CASA Ref: F24/16185-2

Your Ref: SSD-38358962 Auto Email of Tue 20/01/2026 2:48 PM

**RESPONSE TO SUBMISSIONS AND AMENDMENT REPORTS – KERI KERI WIND FARM
CASA COMMENTS**

Figure 03 Light shielding recommendation

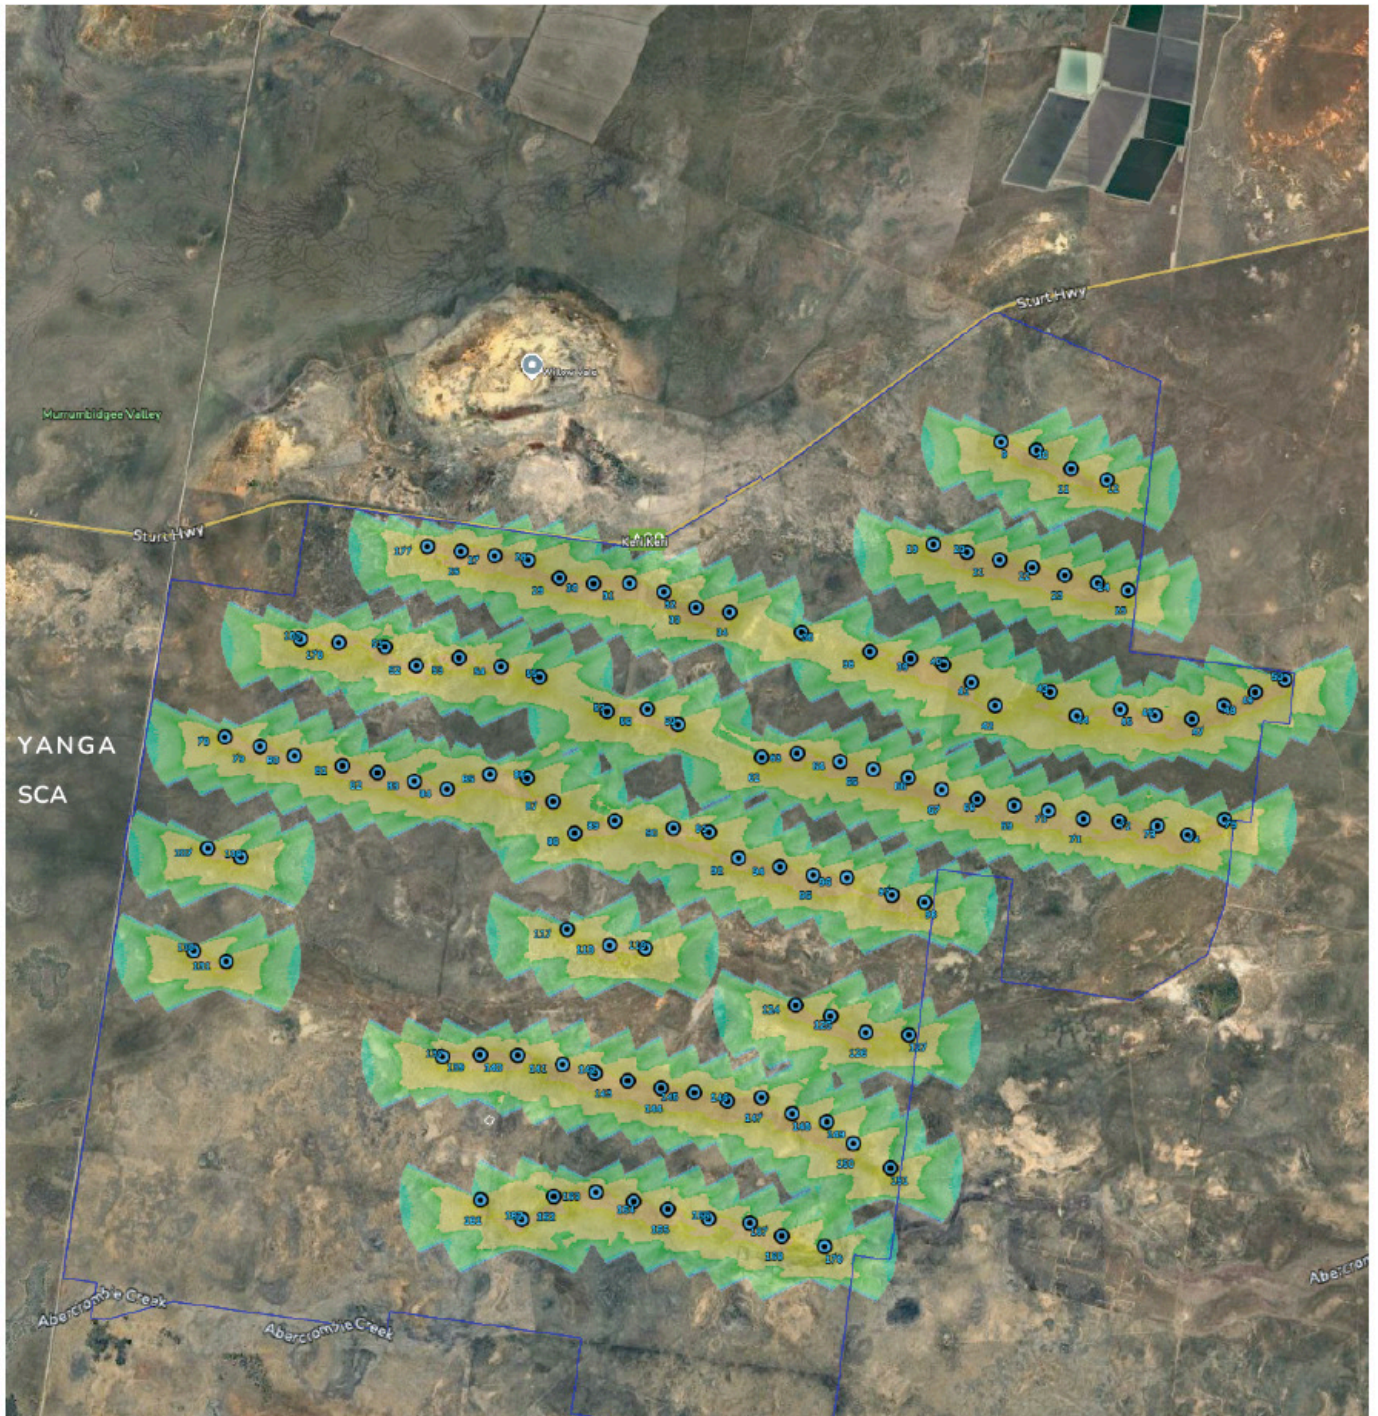
The tip height is 291.5m. Aviation Impact Assessment Technical Memorandum advises: *“Prior to construction, a lighting plan will be prepared in accordance with NASF Guideline D and in consultation with CASA”*. CASA is happy to review lighting plans and also shielding proposals (as described in Landscape and Visual Impact Assessment 3.1 Aviation Lighting).
